August 29, 2016

Project No. 16055

Response to Comments – 7-Unit Building, 30 Merrill Street, Portland, Maine

BRICK SIDEWALK WITH BITUMINOUS BASE
NOT TO SCALE

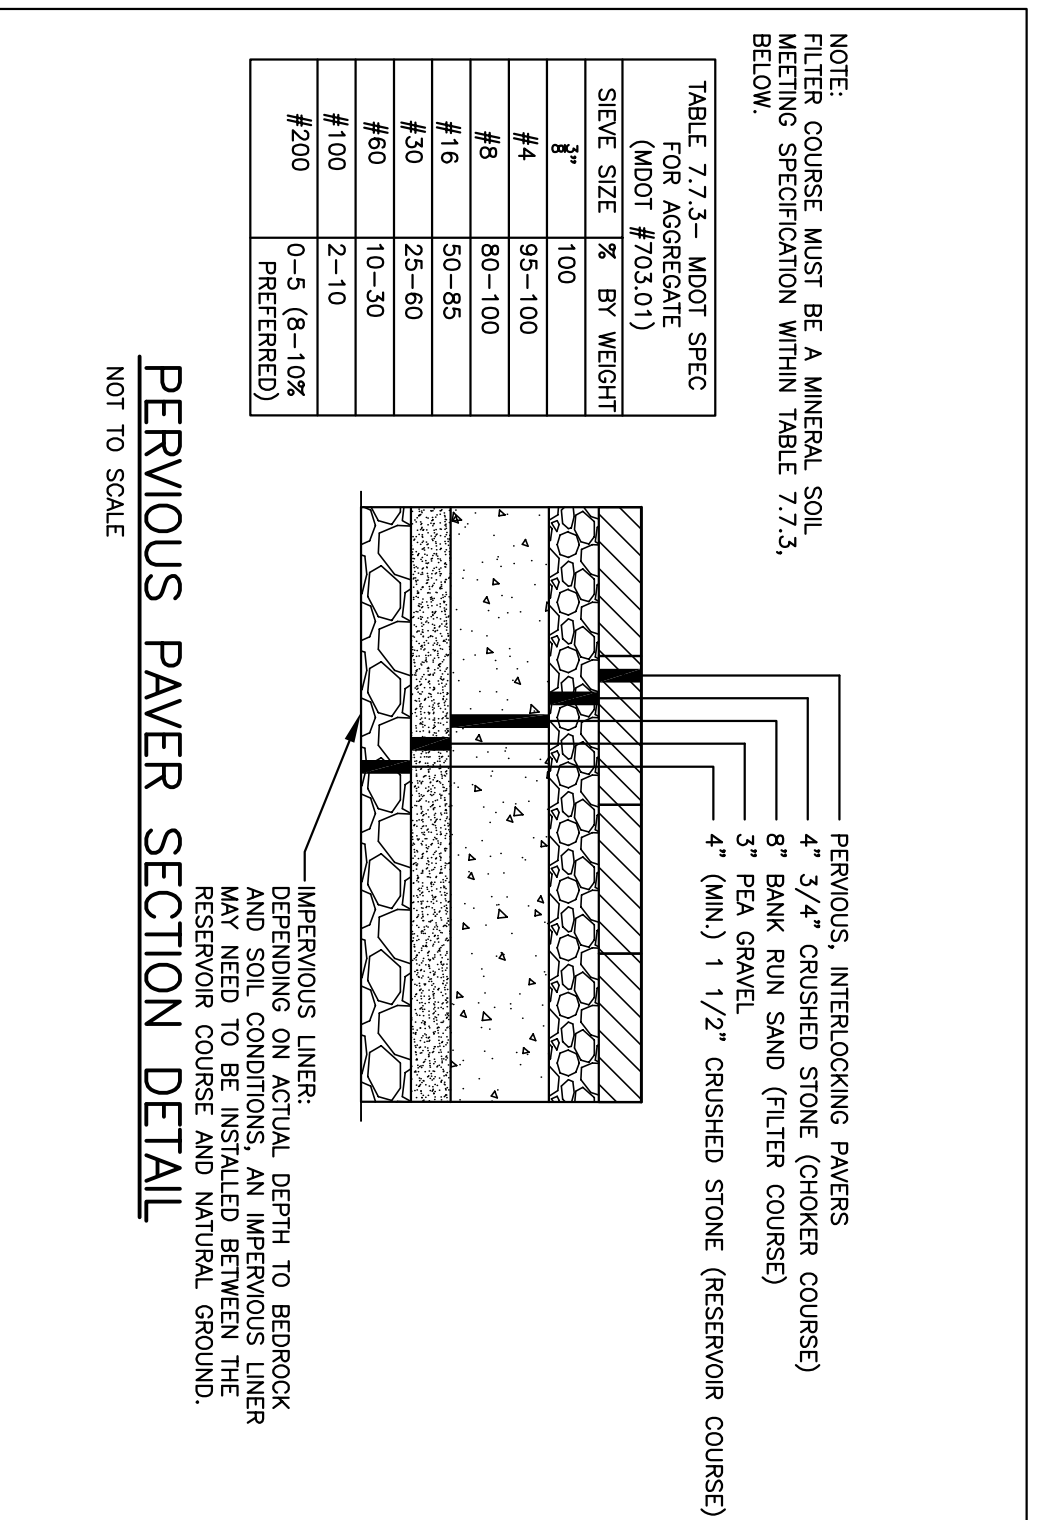
3) *The Applicant should provide a detail for pipe trenches, brick sidewalk repair, and pavement repair within the City of Portland Right-Of-Way per the City of Portland Technical Manual.*

We have added these details to the plans.

PERVIOUS PAVEMENT SECTION DETAIL
NOT TO SCALE

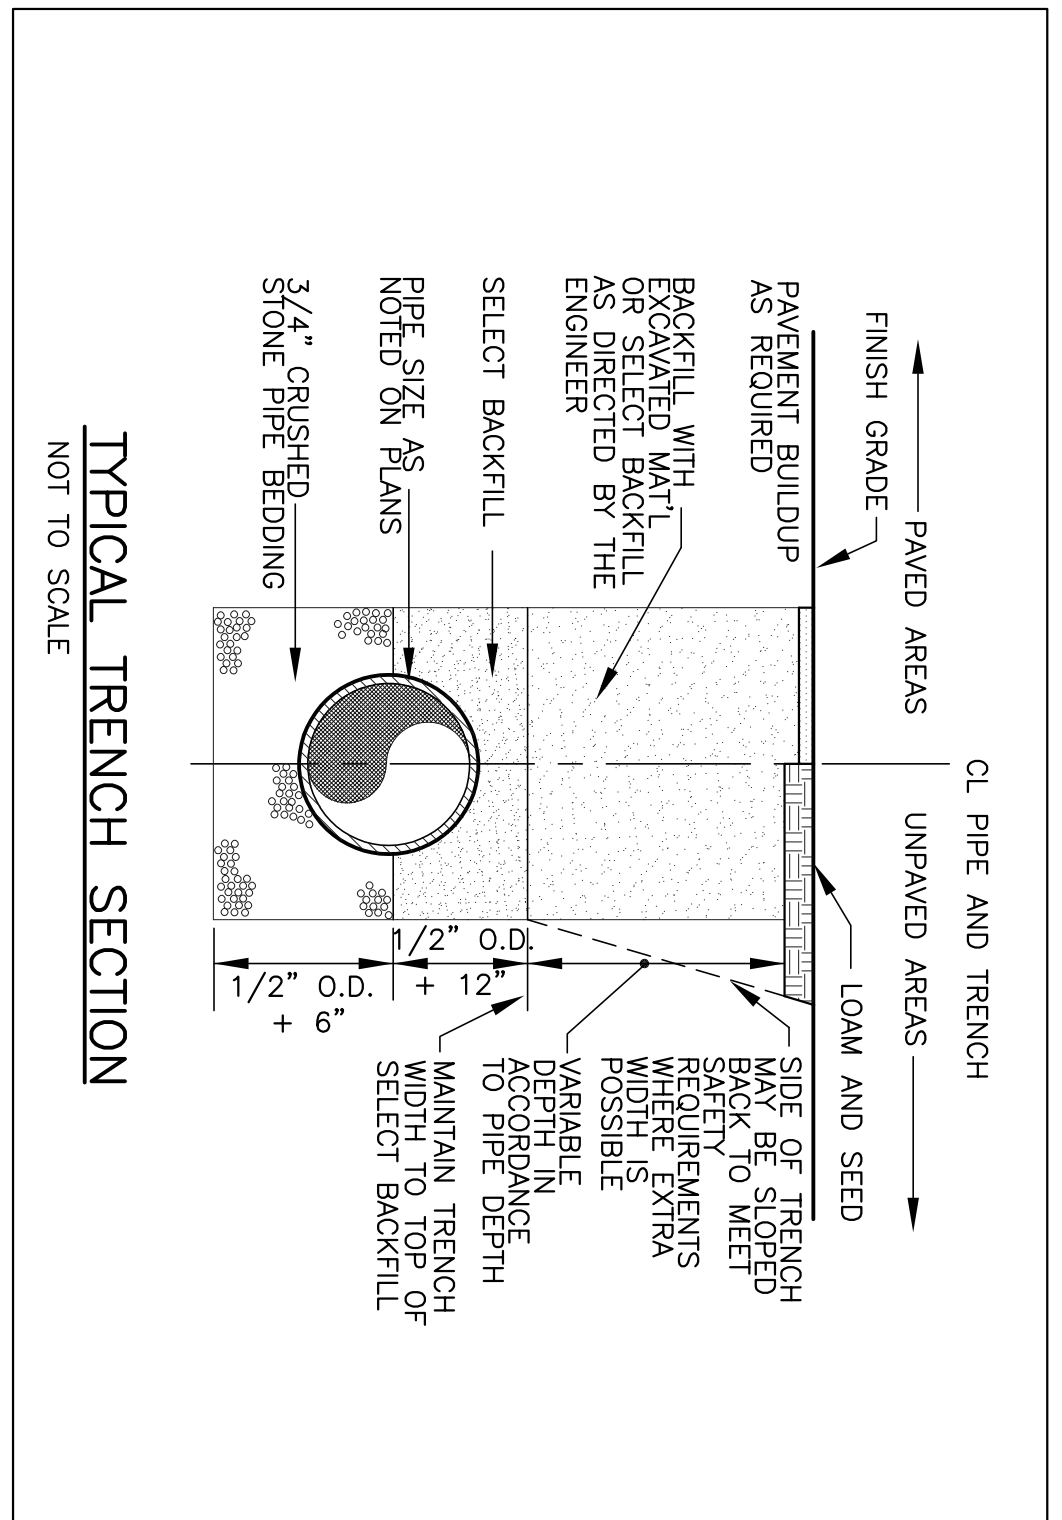
- *The Pervious Paver Section Detail provided on Sheet C2 includes a Filter Layer; however, the Site Plan and stormwater management plan indicate that the limit of the proposed filter bed does not extend over the full area of proposed pervious pavers. A detail should be provided for paver installation in areas outside of the filter bed, to confirm that the entire paver area may be considered pervious. If the additional pavers are not installed in such a way that they are pervious, the impervious surface calculations should be updated, and the filter area should be designed per the Maine DEP Stormwater BMP manual's guidance for "Run-On Modular Pervious Pavement."*

- *The Pervious Paver Section Detail should include specifications for the filter layer per Chapter 7.7 of Volume III of the MaineDEP Stormwater BMP Manual.*

The plans and calculations have been updated to show that the entire parking area and driveway are to be consistently constructed as pervious pavers.

We have added this information to the detail.

BICYCLE RACK SPECIFICATION - BIKE HITCH

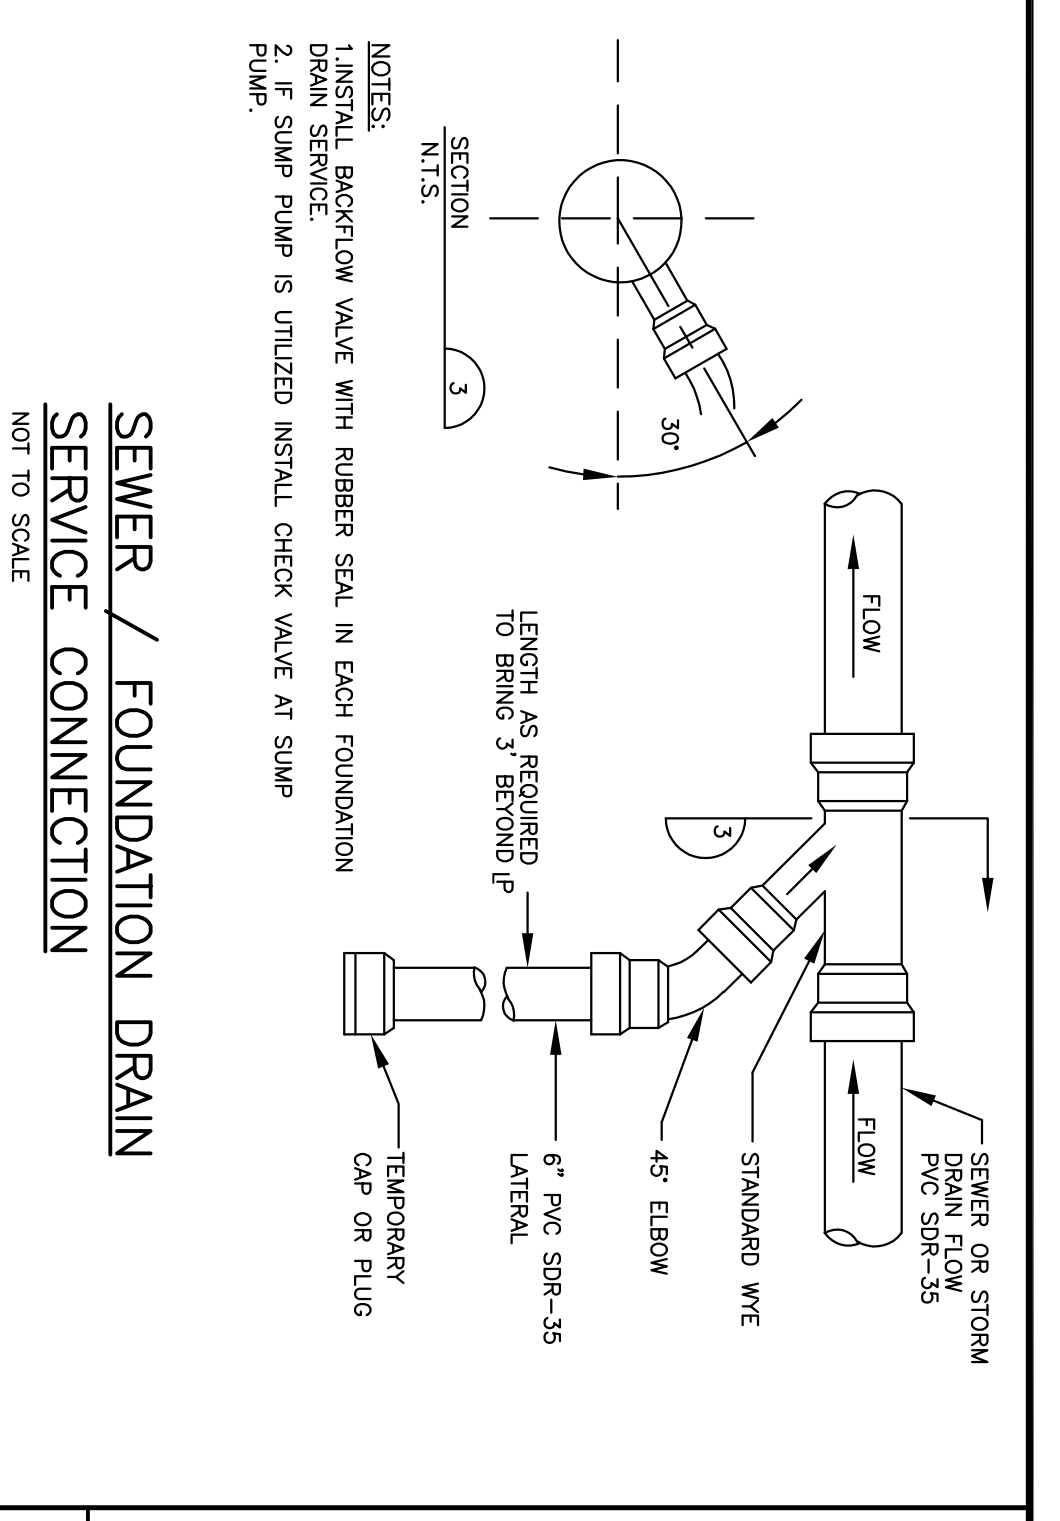
- *Bike Parking.*

To add to your response on this issue, we have added the location of the bike rack on the front sidewalk. We have provided an excerpt from the Technical Design Manual as well. This is located on the last detail sheet, Sheet C5.

13 FENCE DETAIL NEAR CURB  
SCALE: 3/4" = 1'-0"

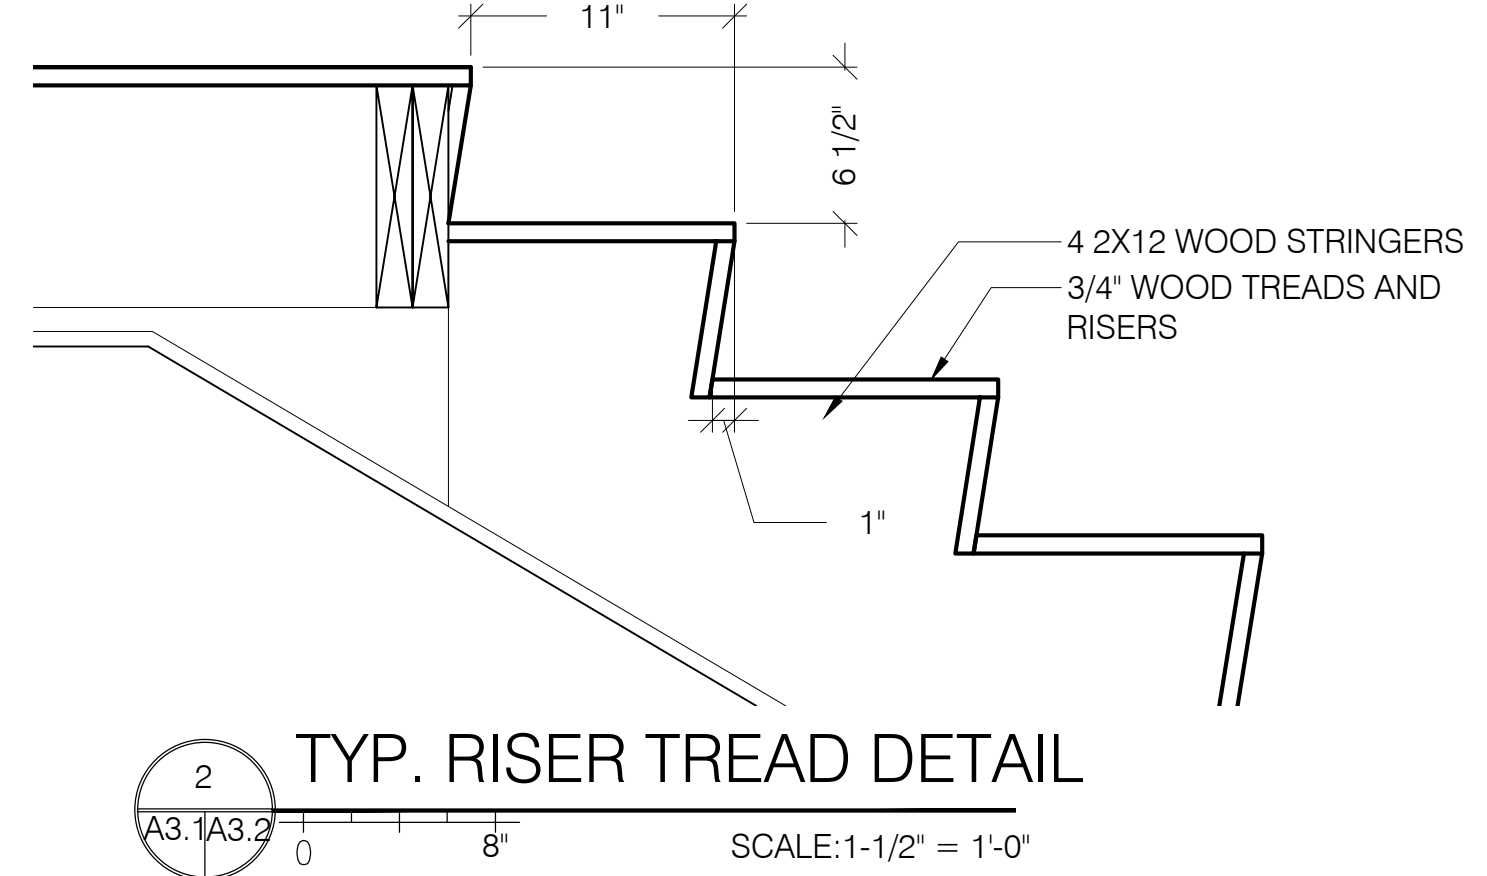
- *A fence is proposed on the edge of the driveway. Details on the fence should be provided.*

Fencing details will be included in the upcoming Landscaping design and details for the site.
